# **Land South of Camp Road, Heyford Park (Phase 9)**

## **Flood Risk Assessment Addendum**

On behalf of **Dorchester Group**

Project Ref: 43374/4000 | Rev: A | Date: April 2018

PHASE 9, HEYFORD PARK, UPPER HEYFORD, BICESTER

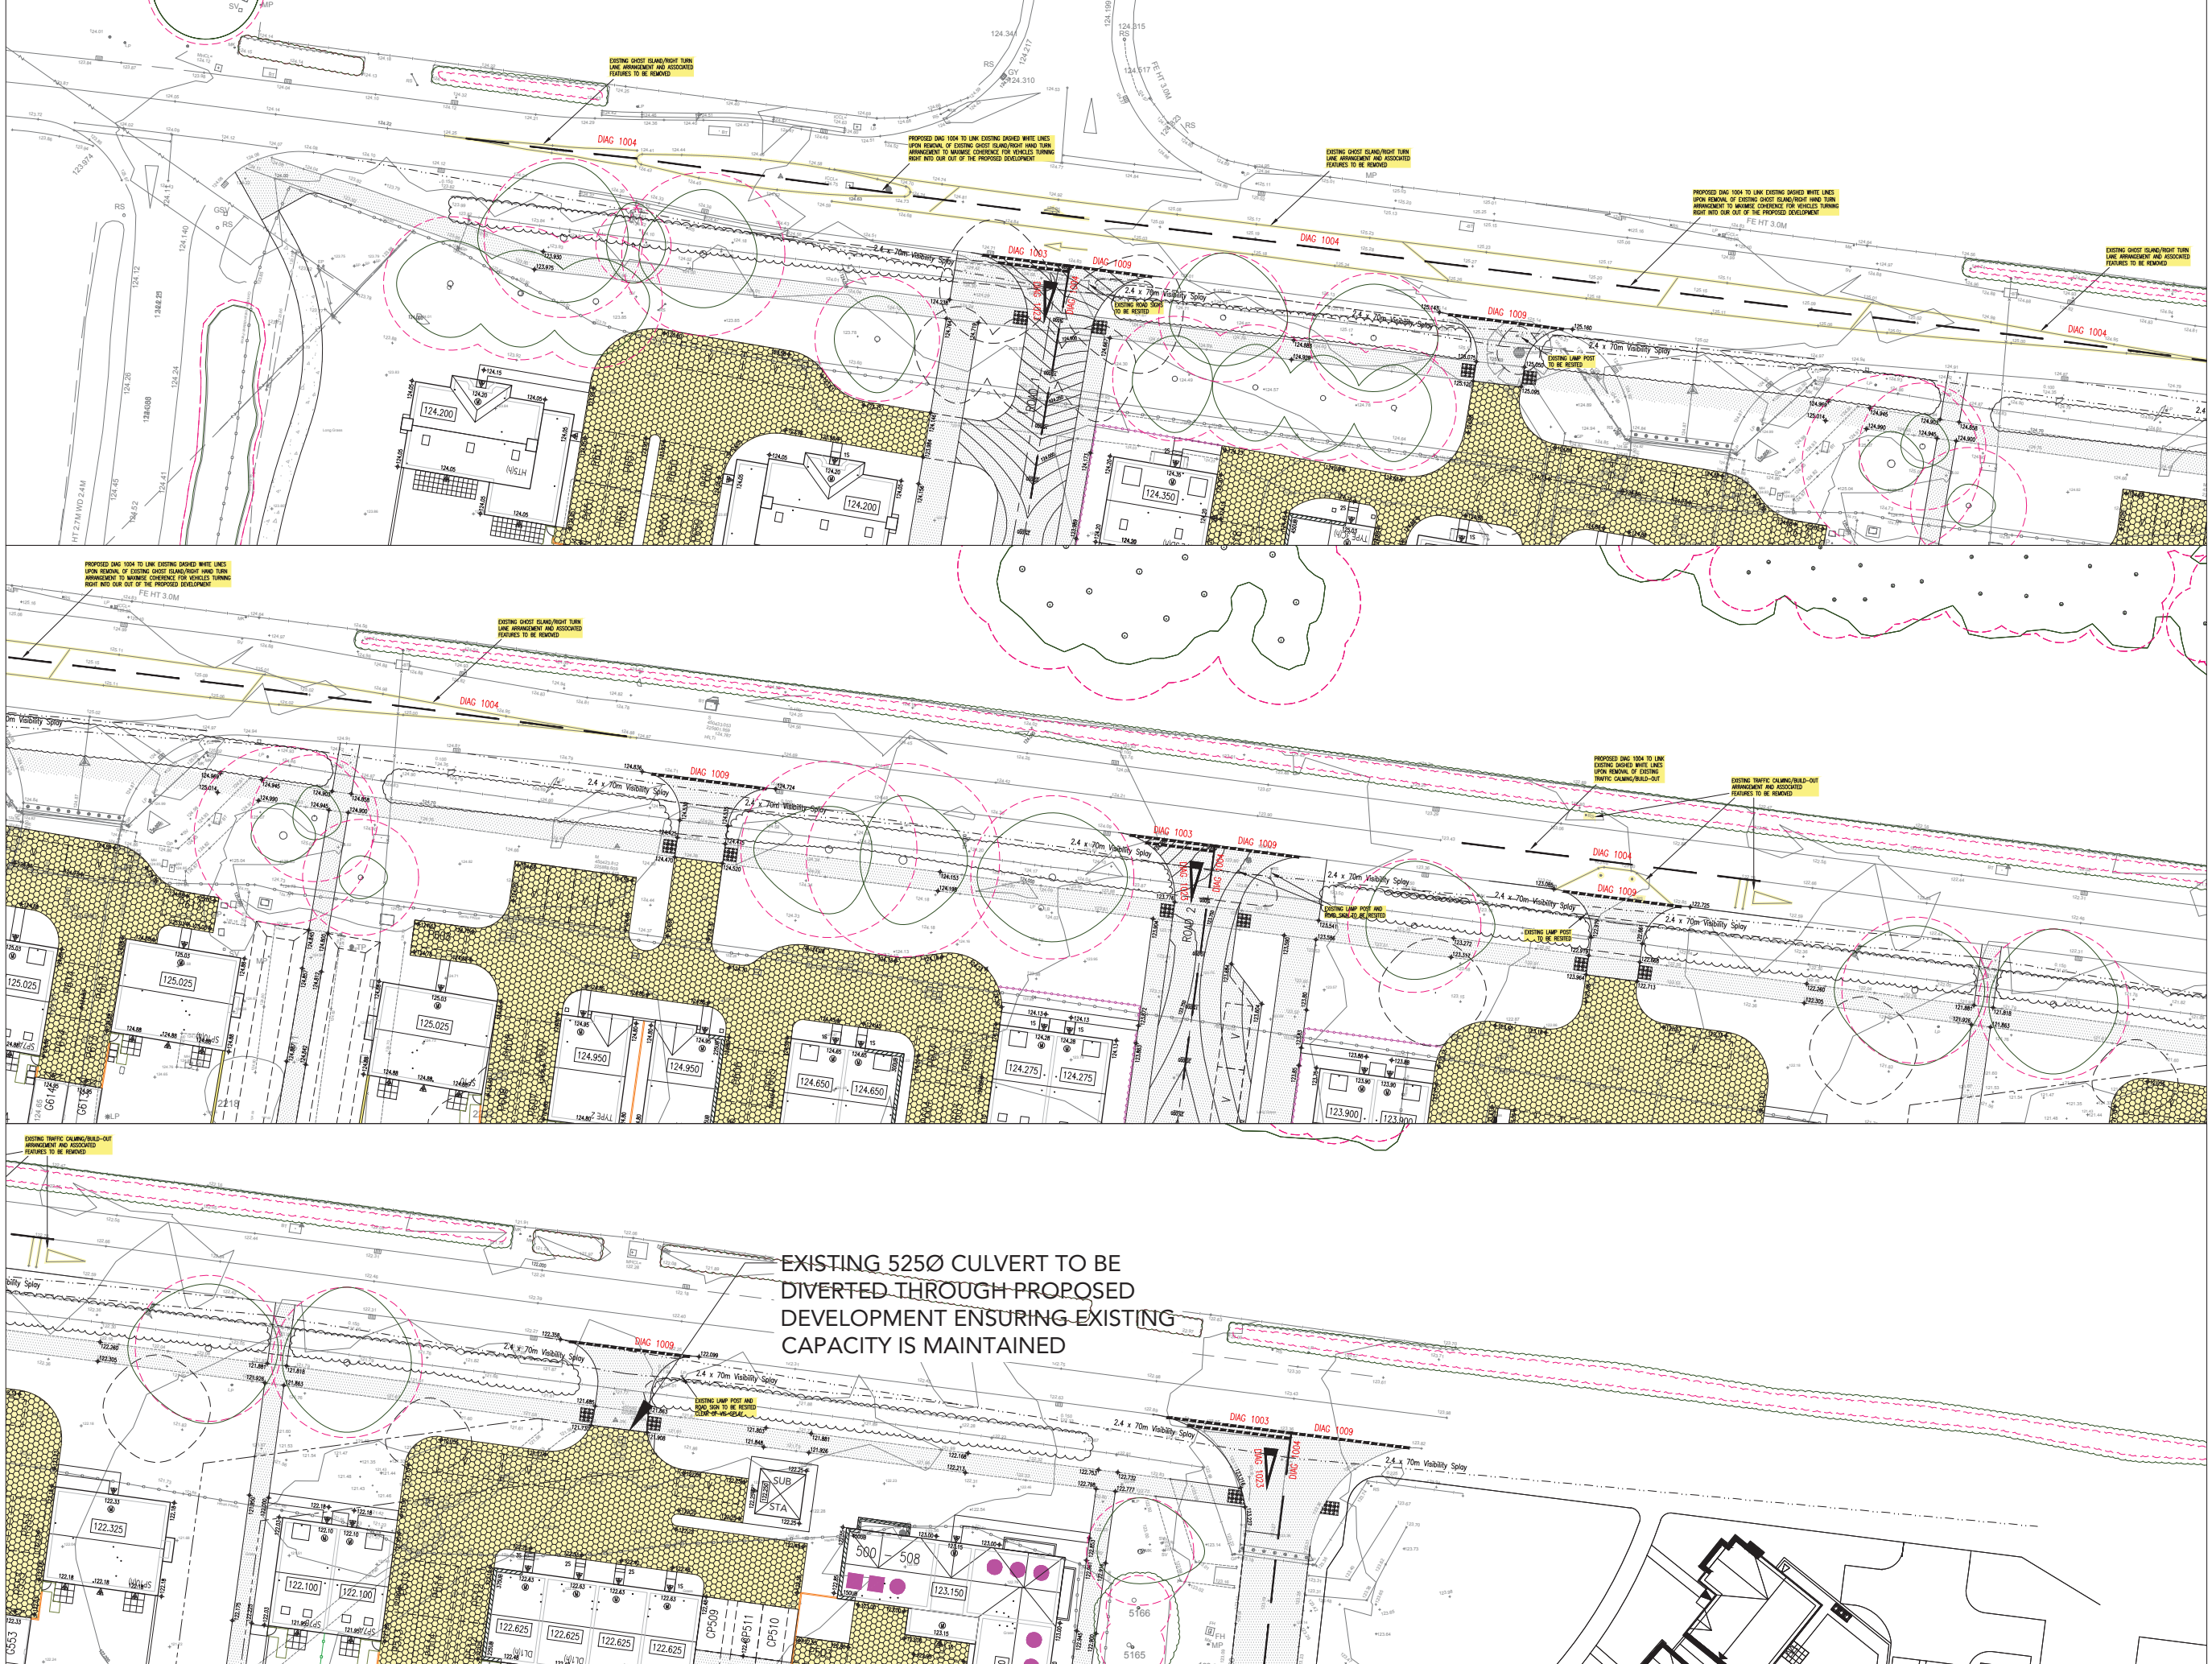
*'The application drawing No.0521/PH9/320 includes a wide range of SuDS techniques proposed to be used for this development. OCC considers that more technical detail needs to be provided as the above referenced drawing is outline in nature. Examples where extra detail is required are: the sizing of swales; the type of permeable paving to be used; cross sections and long section drawings of the pond swales and permeable paving. **Reason for objection.**'*

*Para 6.2.4 of the Flood Risk Assessment (FRA) clarifies that the site, based on ground information, is likely to have some infiltration potential and makes reference to the need to establish the potential for the site. The above referenced drawing in the notes section states that this is not yet established. This needs to be investigated by conducting soakage tests on site to a BRE 365 standard. For a full planning application it is typically expected that infiltration potential for a site would be proven by this stage, thereby adding confidence to the drainage strategy. It appears the site drainage design is still based on there being no infiltration. **Reason for objection.***

*There are no micro-drainage calculations supporting the sizing of the surface water piped network and therefore it cannot be clarified whether site service level standards for no flooding from the drainage system are met by the design. There are no micro-drainage calculations for the SUDS elements such as Swales and Permeable Paving provided. **Reason for objection.***

*There appears to be no information supplied with regard to overland flood routing when exceedance of the capacity of the site drainage system occurs. For example, the provision of a flood routeing plan. **Reason for objection.***

*There were is no management / maintenance of SuDS plan provided with the application. Paragraph 6 of the FRA states that further discussion with the local authority will be required to discuss the approach for adoption and future maintenance. With regard to maintenance of the proposed pond, it is not clear whether the proposed slope range will be suitable for maintenance using a mower. **Reason for objection.**'*

- 3.3. Drawing '*0521/PH9/320 Rev C*' indicates that the proposals for Phase 9 include for the diversion of the culvert through the development in line with the proposed masterplan layout, whilst maintaining its existing capacity. Considering that the '*Flood Risk Assessment and Drainage Strategy*' proposes to control discharge from Phase 10 to match the existing greenfield QBAR rate, there will be a net reduction of flows entering the culvert from Phase 10 for the more significant storm conditions. The proposed surface water drainage strategy for Phase 9 as shown in '*0521/PH9/320 Rev C*' will therefore not be compromised by flows entering the site from Phase 10.

- 4.1. Infiltration testing on Phase 9 was undertaken by Hydrock and presented within the '*Desk Study and Ground Investigation*'.
- 4.2. The '*Drainage Statement*' (Focus On Design, April 2018) provides commentary on the results of the infiltration testing and their implication within the proposed surface water drainage strategy. This statement can be found in **Appendix A**

- 5.1. The detailed design of the proposed SuDS components has been undertaken by Focus On Design.
- 5.2. Details of proposed SuDS components can be found in the '*Drainage Statement*' (Focus On Design, April 2018), whilst the proposed drainage strategy layout is indicated within drawing '*Drainage Strategy Plan*' 0521/PH9/320 – Revision C (Focus On Design, April 2018).
- 5.3. The sizing of each component has been undertaken by Focus On Design using '*MicroDrainage*' software, the results of which are appended to this addendum.
- 5.4. The '*Drainage Statement*', drawing 0521/PH9/320 Rev C and accompanying '*MicroDrainage*' calculations can be found in **Appendix A**

- 6.1. In the event of a rare storm event greater than the design level of the proposed surface water drainage strategy, the capacity of the drainage could be temporarily exceeded and drainage inlets could be bypassed creating overland flow.
- 6.2. It is recommended that all buildings should be provided with internal threshold levels raised 150mm above surrounding ground levels. Overland flows will be managed within the proposed highways and will be directed around buildings towards the Gallos Brook.
- 6.3. An exceedance flood routing assessment has been undertaken using the proposed highway and plot levels. The results of this are presented within drawing 33374/4001/510 within **Appendix B**
